Reference: Engineering Services
93 Big J St.
Erwin, NC 28339
TE&D Project No.: 2501-020522

As requested, a representative of Tyndall Engineering & Design, PA (TE&D) was on-site to observe the following item(s):

- 1) Analyze and inspect the tall foundation walls at the front porch.

FOUNDATION PLAN
 SCALE 1/4" = 1'-0"

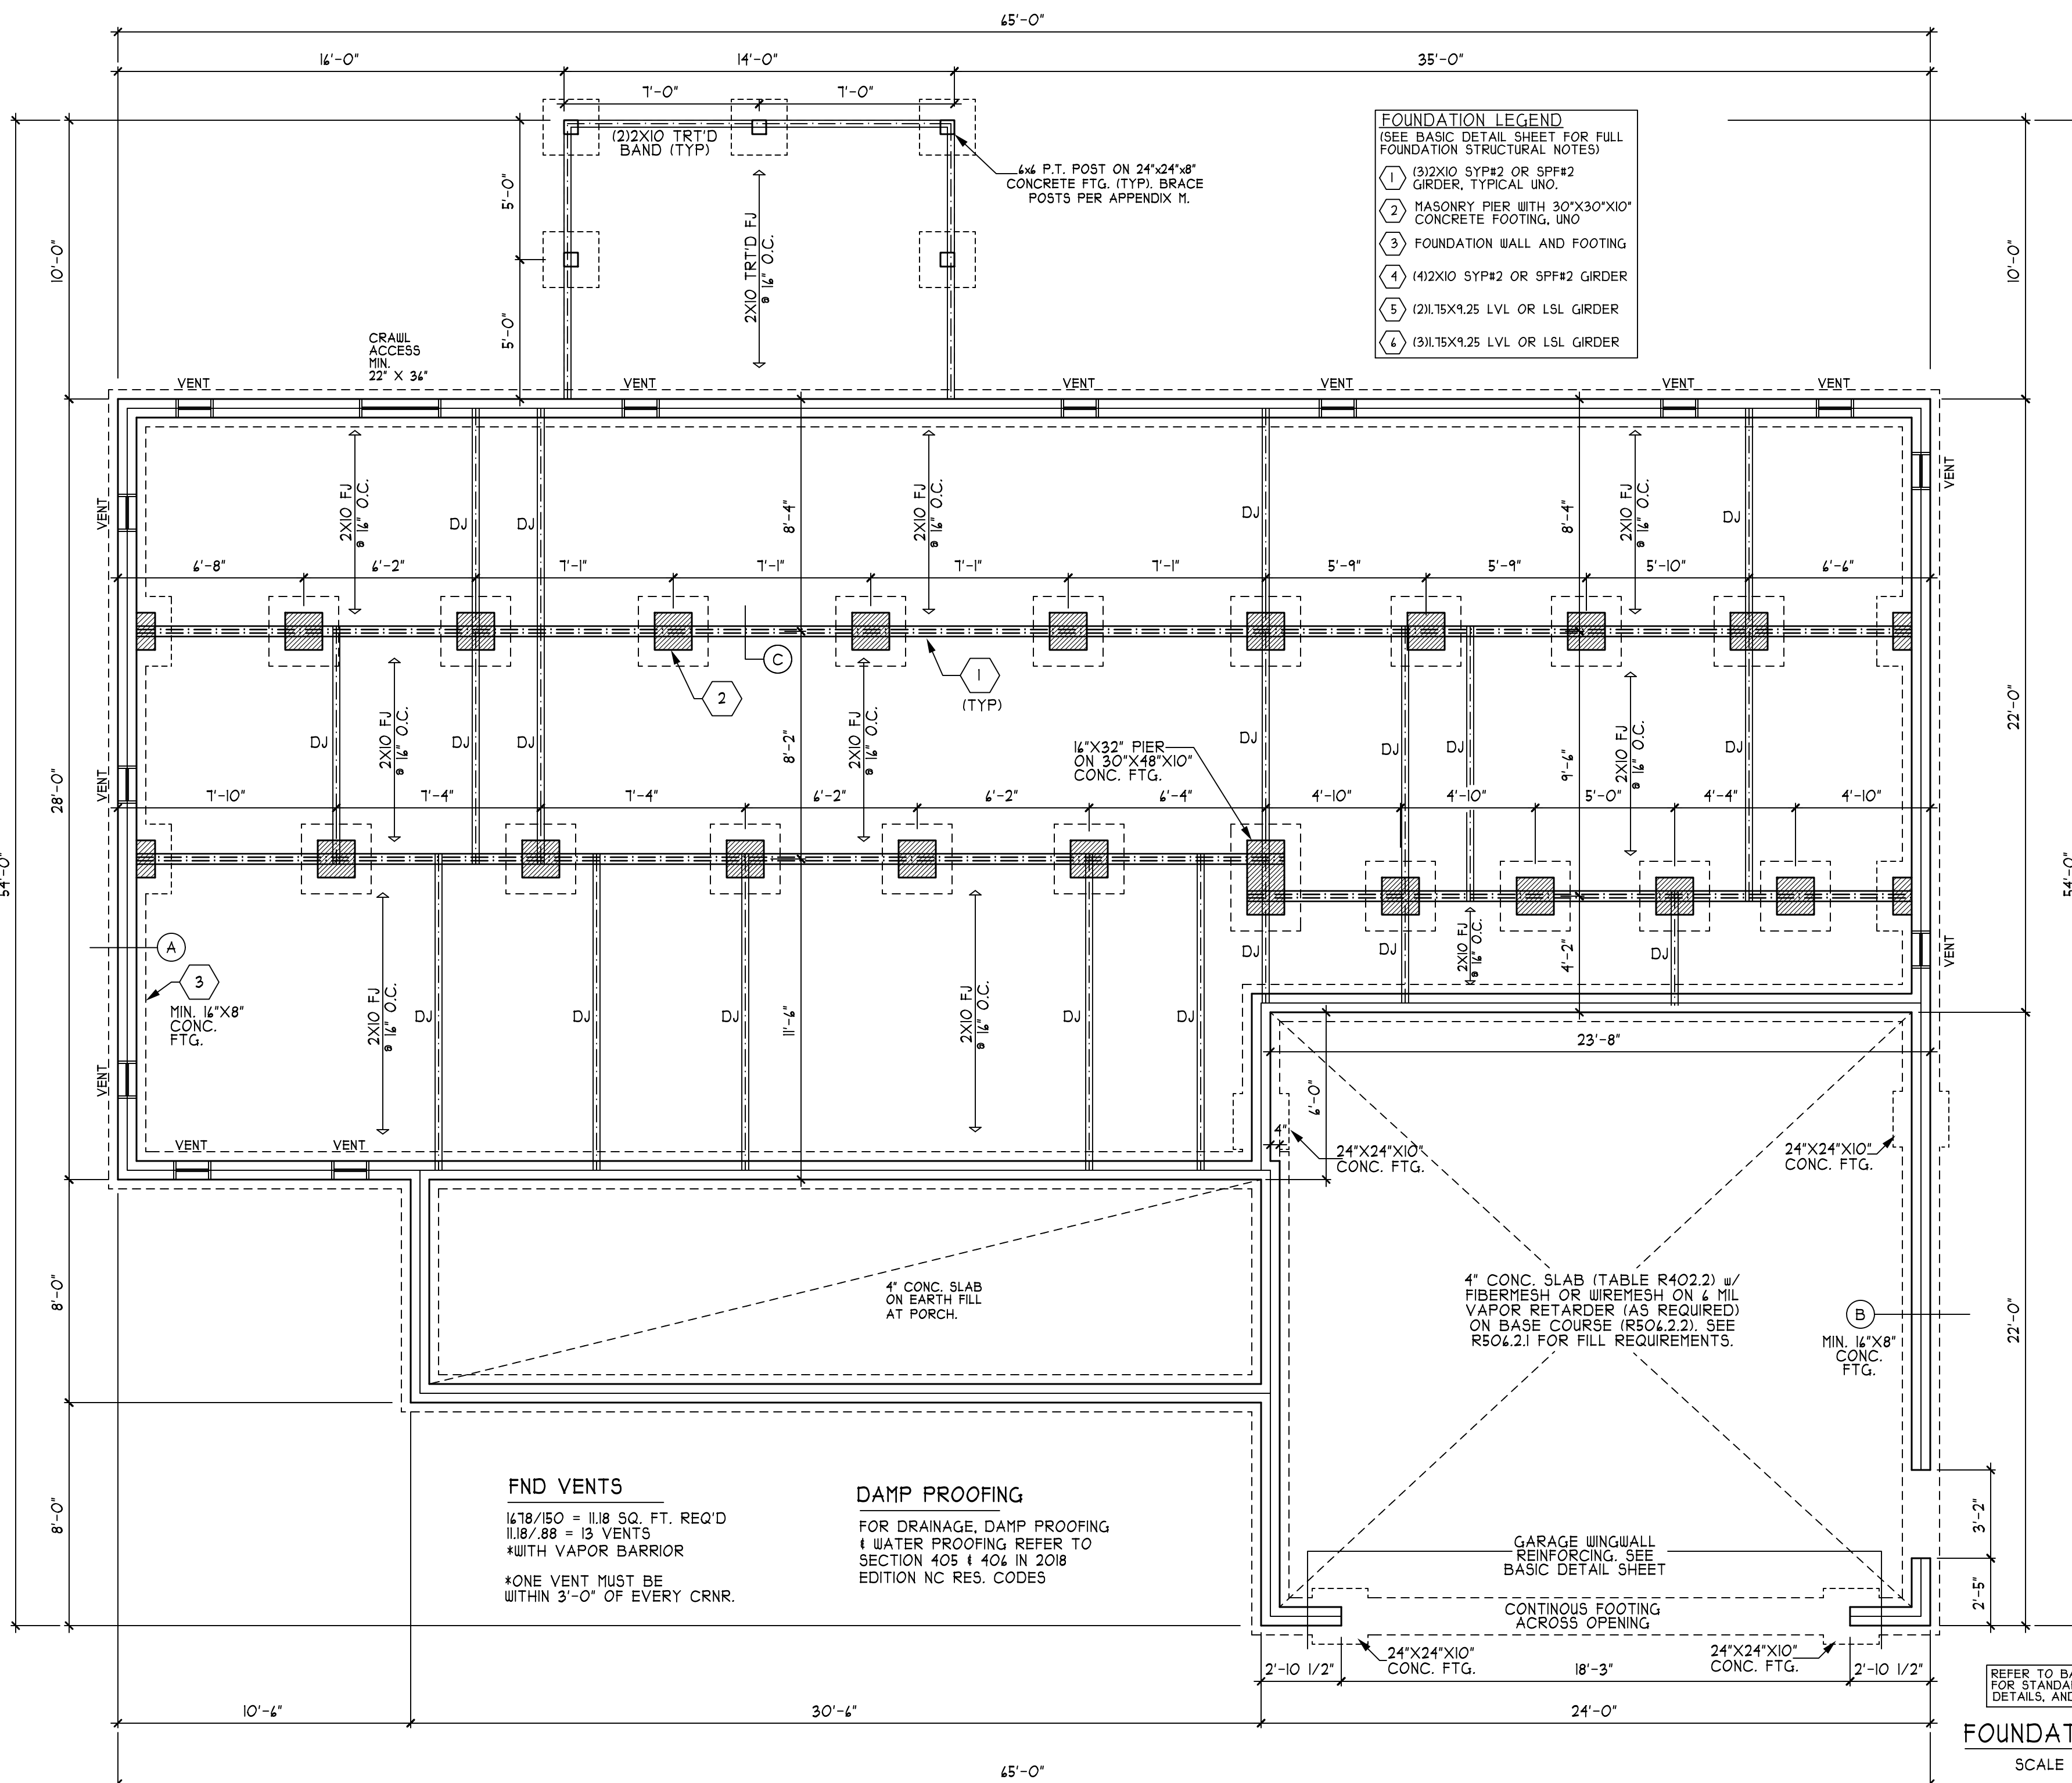
- 1) We observed the 12" thick masonry/CMU foundation walls were constructed to maximum heights of 7'-0" above the footing. We also understand that unbalanced fill at final grade will be no greater than 5'-0". Based on our observations and analysis, the "as-built" walls remain suitable and will provide the required support for the anticipated loading conditions.
